From: Longridge Town Council <clerk@longridge-tc.gov.uk>
Sent: 19 March 2019 20:38
To: planning
Cc: clerk@longridge-tc.gov.uk
Subject: COMMENTS ON PLANNING CONSULTATIONS FROM LONGRIDGE TOWN COUNCIL

Cllr Ashcroft left the meeting at 7.20pm for the Council to consider the application.
3/2018/0975 - land to the East of Chipping Lane, Longridge

LTC - would like to draw the points/concerns below to the officer's attention:

PHASE 2 / 3
 PLANNING LAYOUT

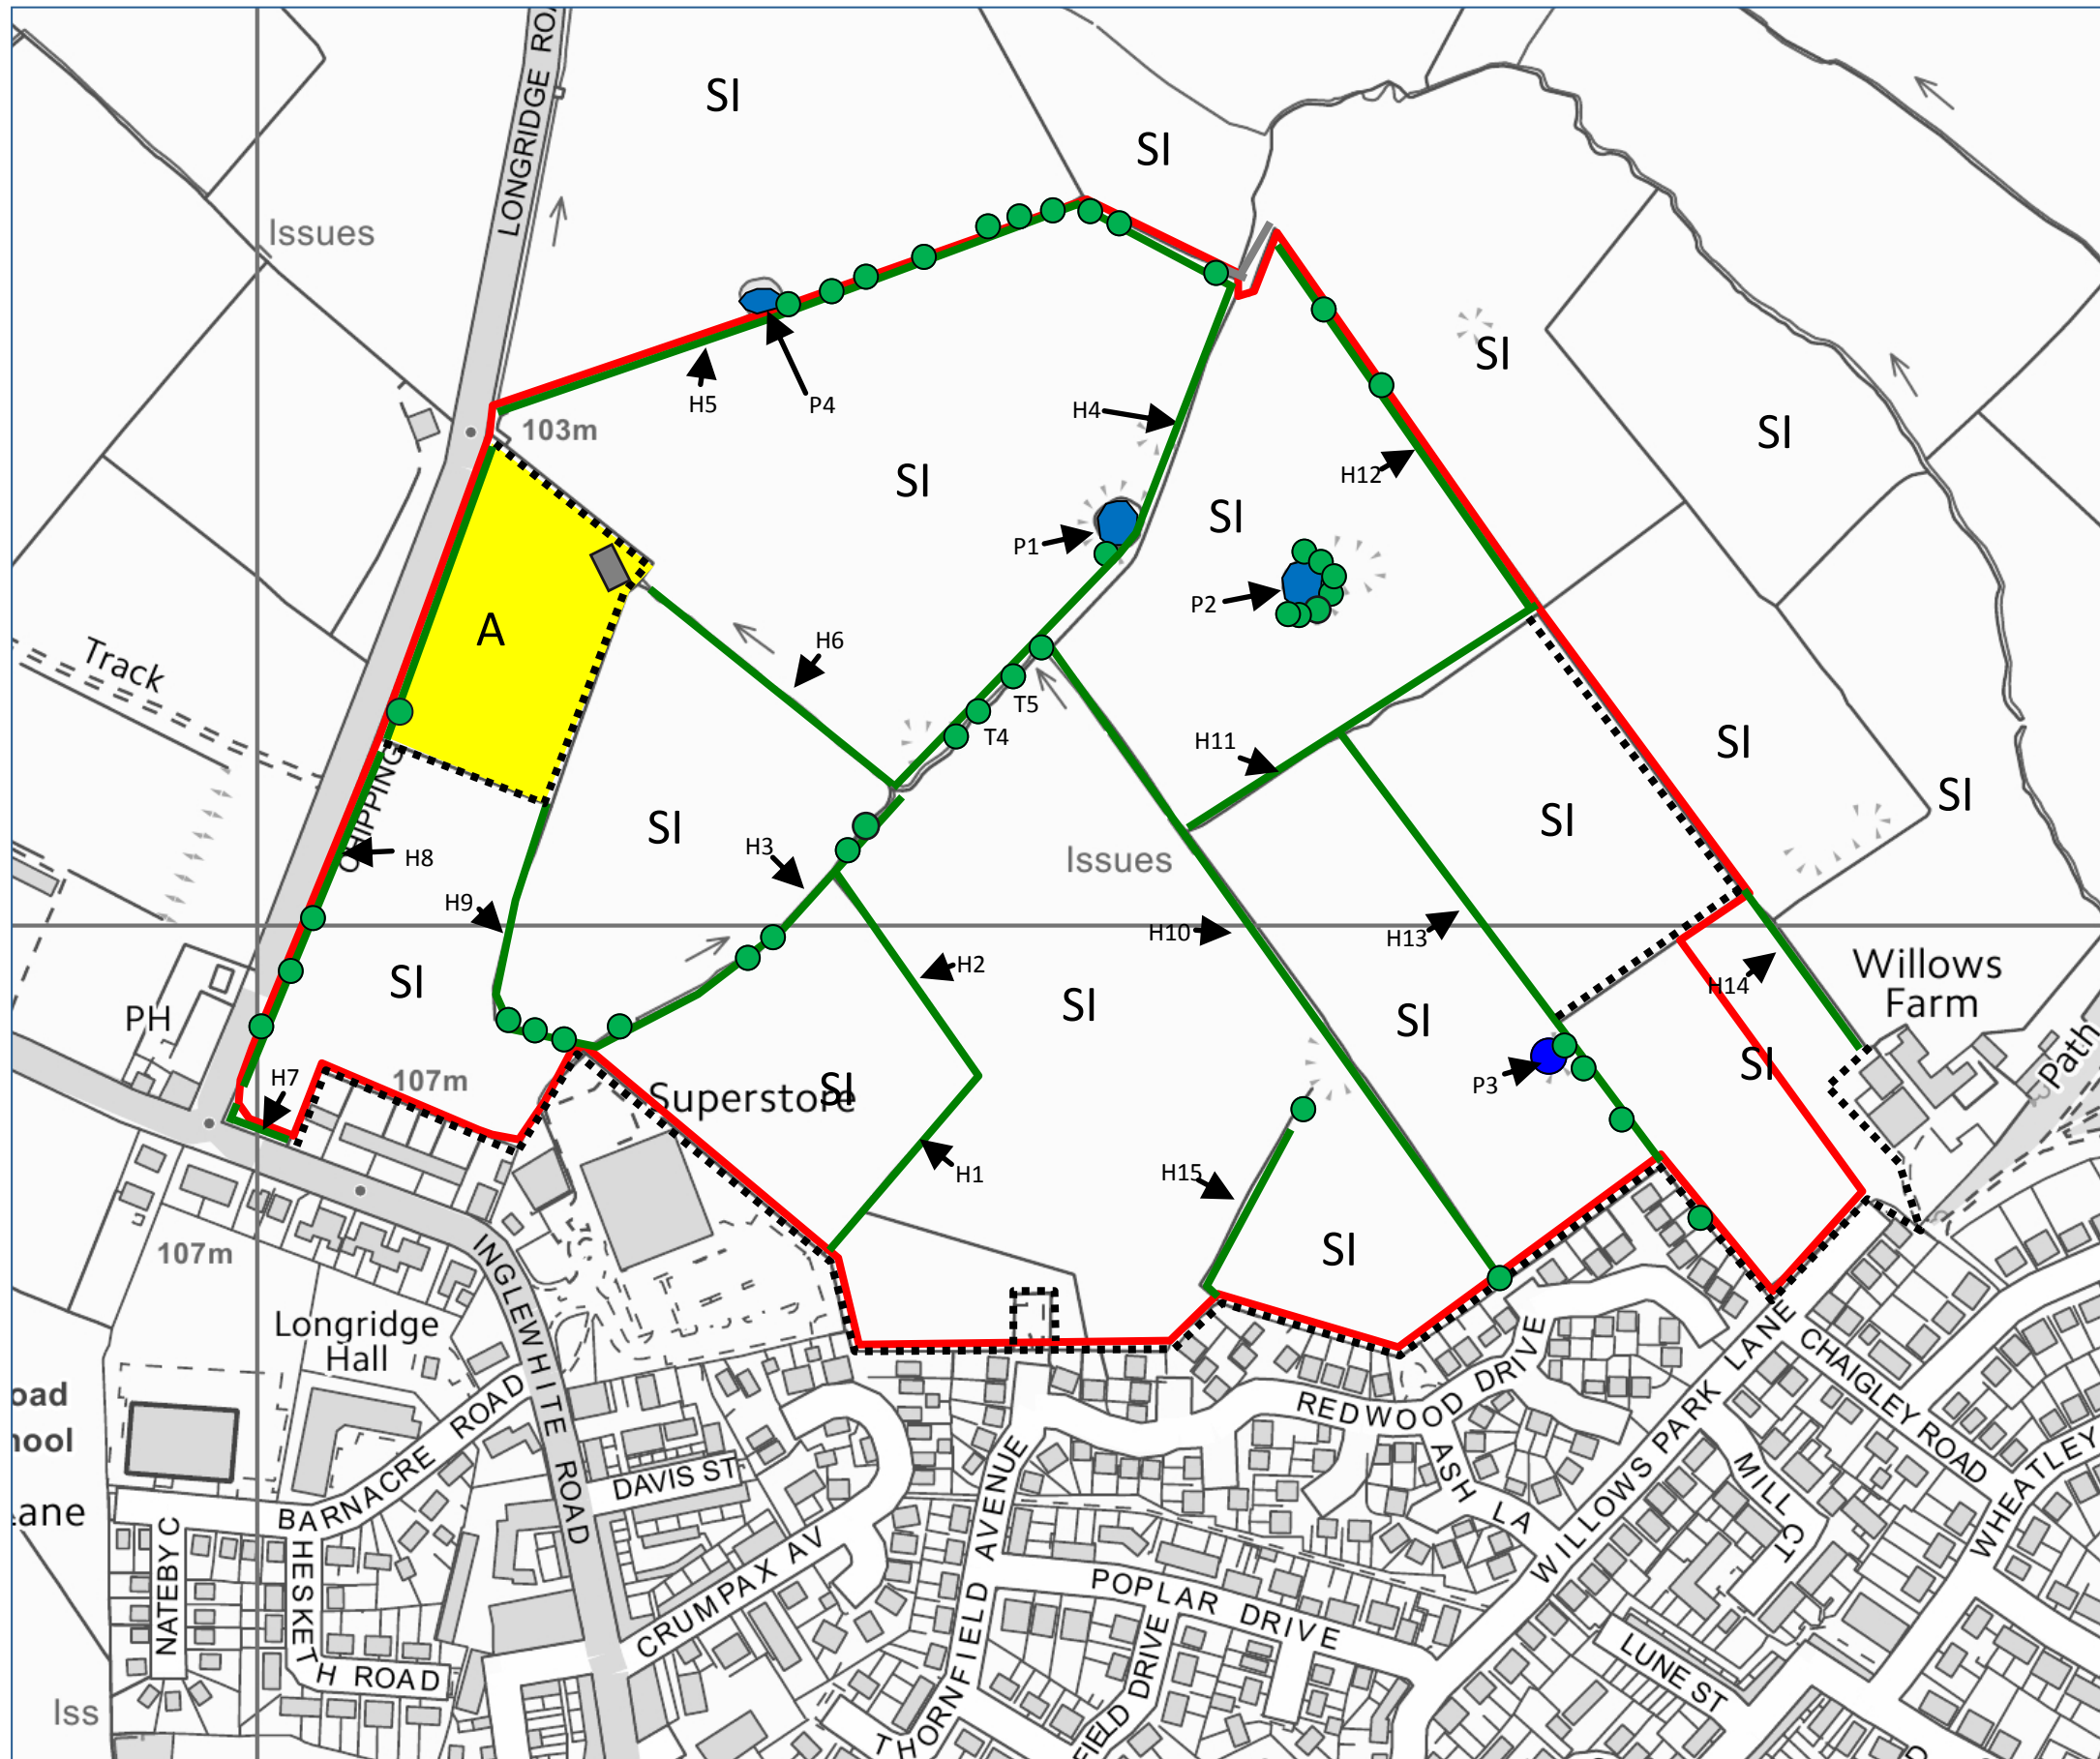
1. Footpath - a cause for highway concerns in regards to pedestrian/cyclist safety when resident reversing from his/her drive
2. Trim trial - in the wrong place LTC feel it should be nearer to the play area.
3. Would like to see retention of original hedgerow.
